**PLANNING WORKSHEET 11 – DELEGATED / PCG REPORT - GENERAL**

<b>Application Ref.</b>	22/00863/FUL	
<b>Site Address</b>	Land Including Littlewood House Wheatley Road Sturton Le Steeple Retford Nottinghamshire	
<b>Proposal</b>	Demolition of an Existing Bungalow and erection of a Detached House and Garages with new vehicular access	
<b>Case Officer</b>	Eleanor Grant	
<b>Decision Level</b>	Delegated	
<b>Recommendation</b>	Refuse	
<b>Reason(s) for PCG referral</b>		
<b>PCG Sign off and date</b>		
	<b>Signature</b>	<b>Date</b>
<b>Case Officer</b>	Ellie Grant	09/08/2022
<b>Authorised signing Manager</b>		10 <sup>th</sup> August 2022

SITE PLAN

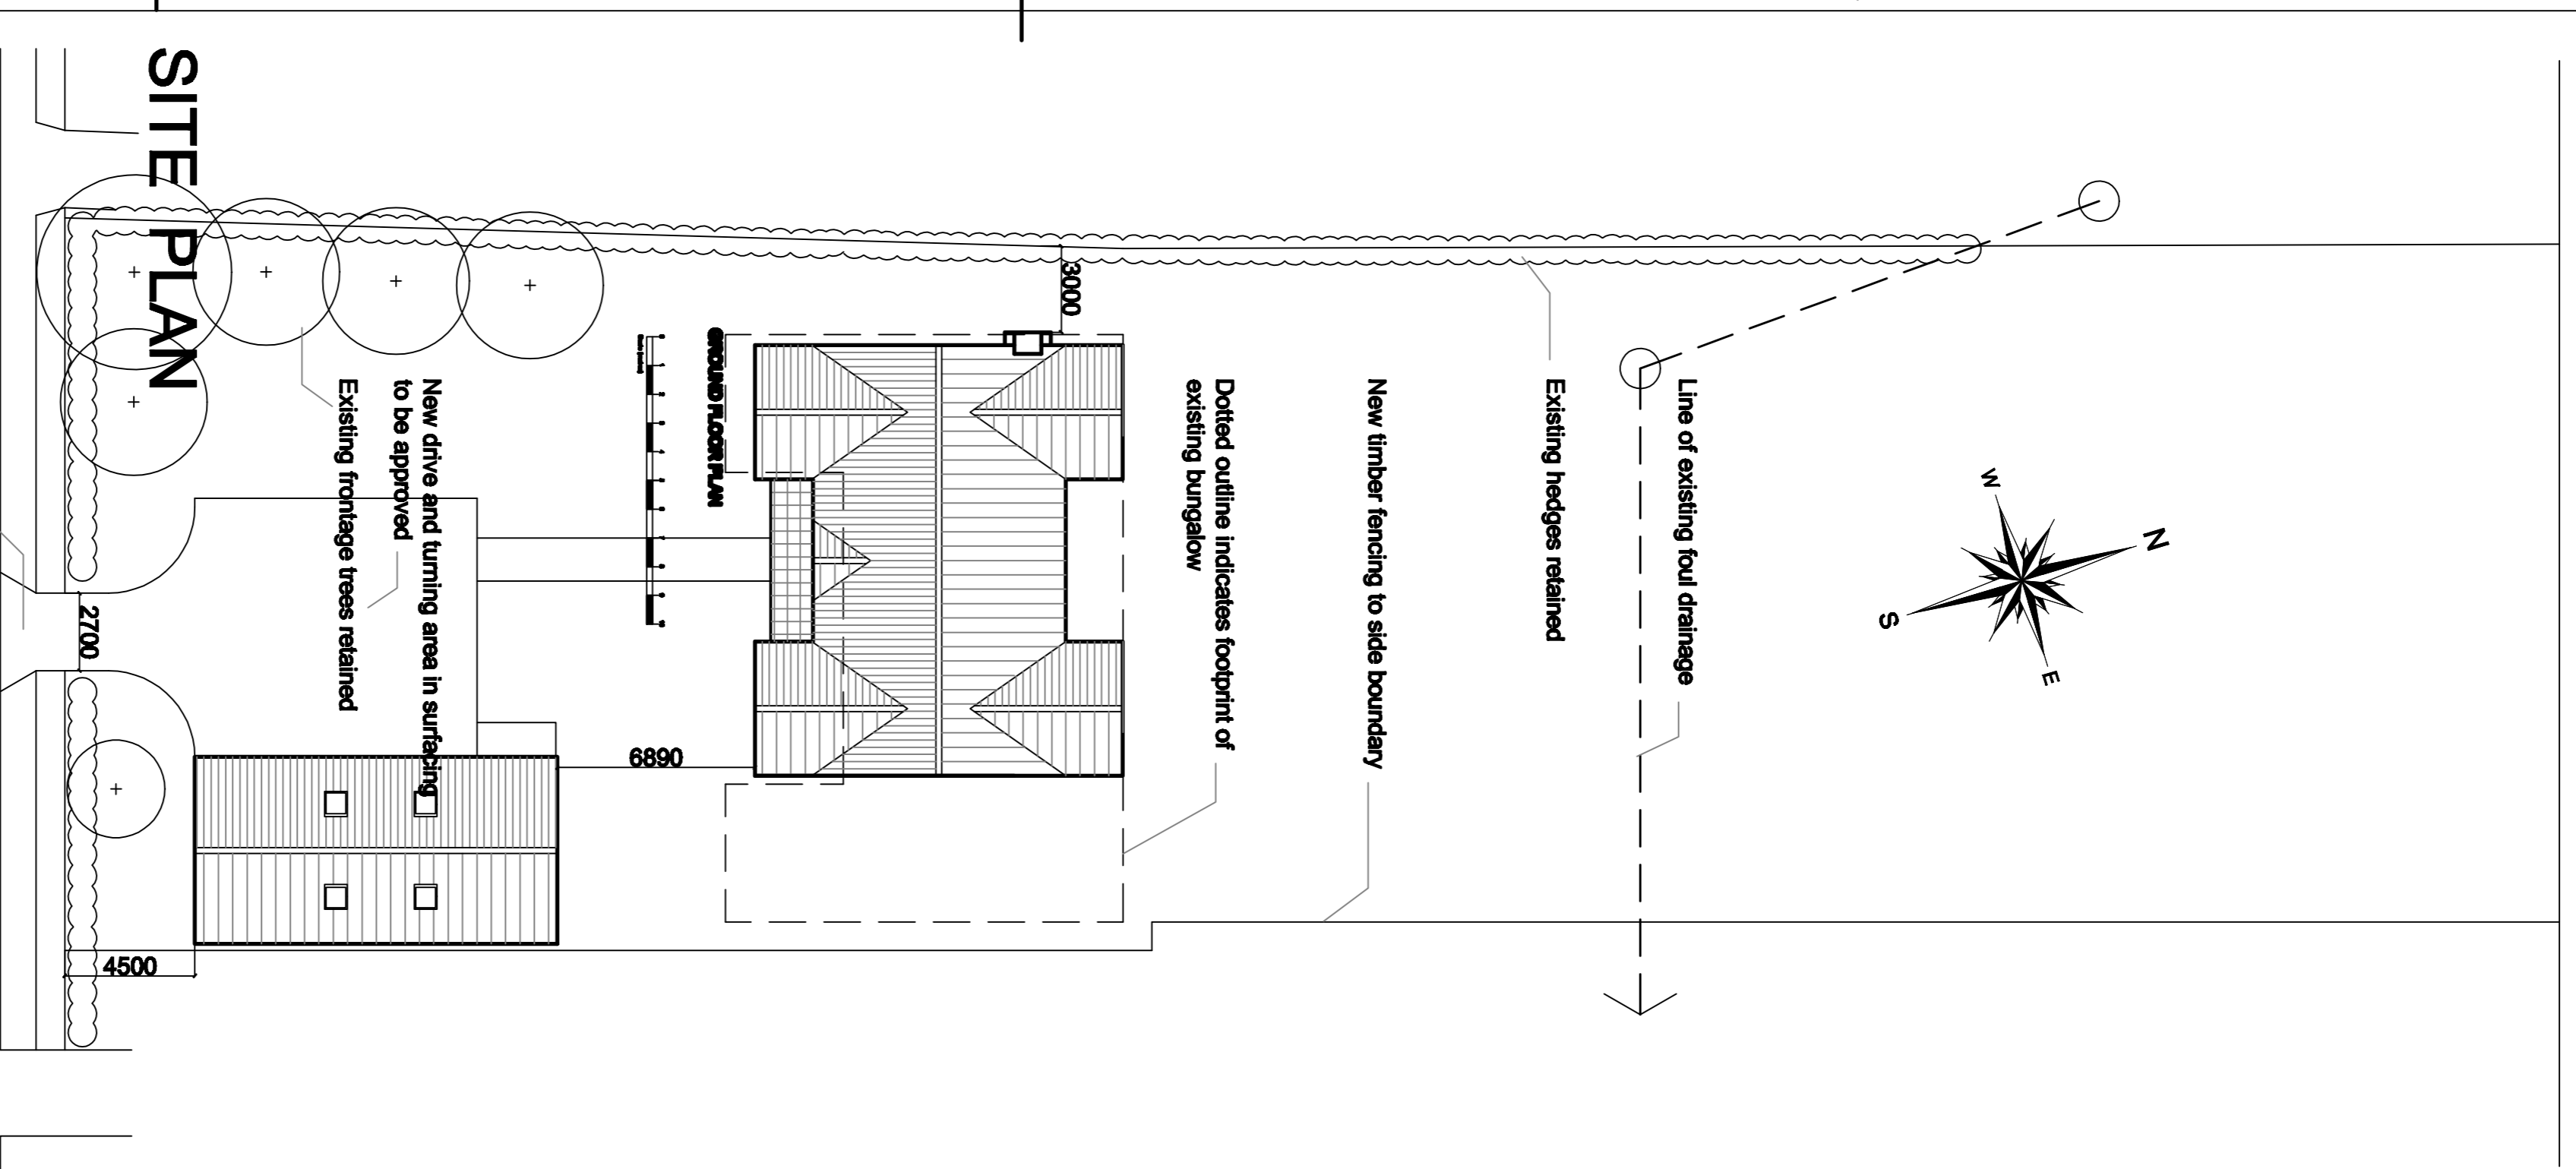
The application proposes to rebuild a large bungalow as a two storey house. The block plan shows that the footprint of the dwelling will be reduced by around 5 metres in width from the south-east. The replacement dwelling will offer in the region of 320sqm of floorspace over two floors, approximately 80 sqm more than the original dwelling (approx. 240sqm originally). Given that the original dwelling had a larger footprint, albeit at single storey only, the dwelling is considered to be a similar footprint to the existing dwelling for the purposes of policy DM3iii.

The Little Bungalow is unlikely to be affected by the replacement dwelling. The dwelling will be reduced approximately 5 metres from the north-eastern boundary and the garage will be some distance away from the property boundary.

The proposed dwelling will sit 3 metres from the boundary with Cranleigh, a bungalow to the north-west. Cranleigh has photovoltaic panels fitted to the south-east side roofslope which are roughly 2-3 metres from the shared boundary. The impact to photovoltaic panels is a material consideration in planning applications, as set out within McLennan R v Medway Council & Anor (2019) EWHC 1738 (Admin) (10 July 2019) where it was stated 'interference with the solar panels is a material planning consideration.....in addressing, (however modestly, on an individual scale), issues of climate change'.

The site plan indicates that trees within the frontage shall be retained, as will the hedgerows on the frontage and north-west side elevation. There will be a minor loss of hedgerow to create the new vehicular access.
